PLANNING AND COMMUNITY DEVELOPMENT

Subject: PPR-17-055 2nd Review

SHOPS AT MCLAUGHLIN II

1 of 10 SITE  
PLAN

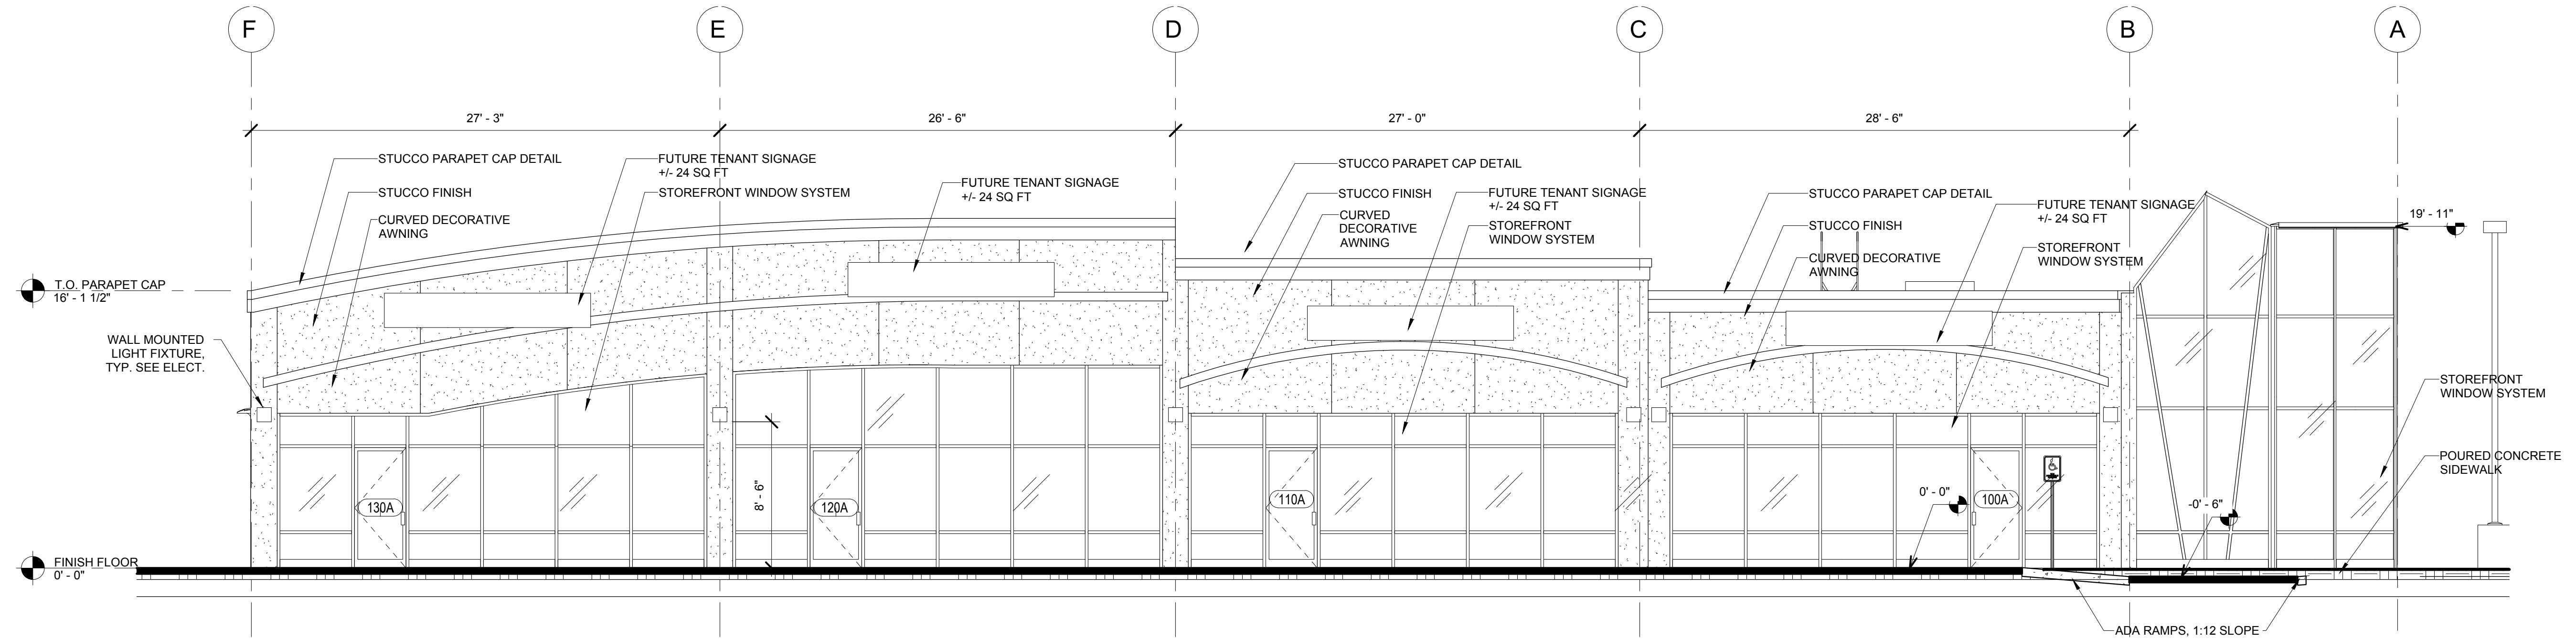
Change the title to Grading and Erosion Plan

Remove the proposed drainage map from the site development plan set and include the drainage map in the drainage report.

Title has been revised.

Sheet has been removed.
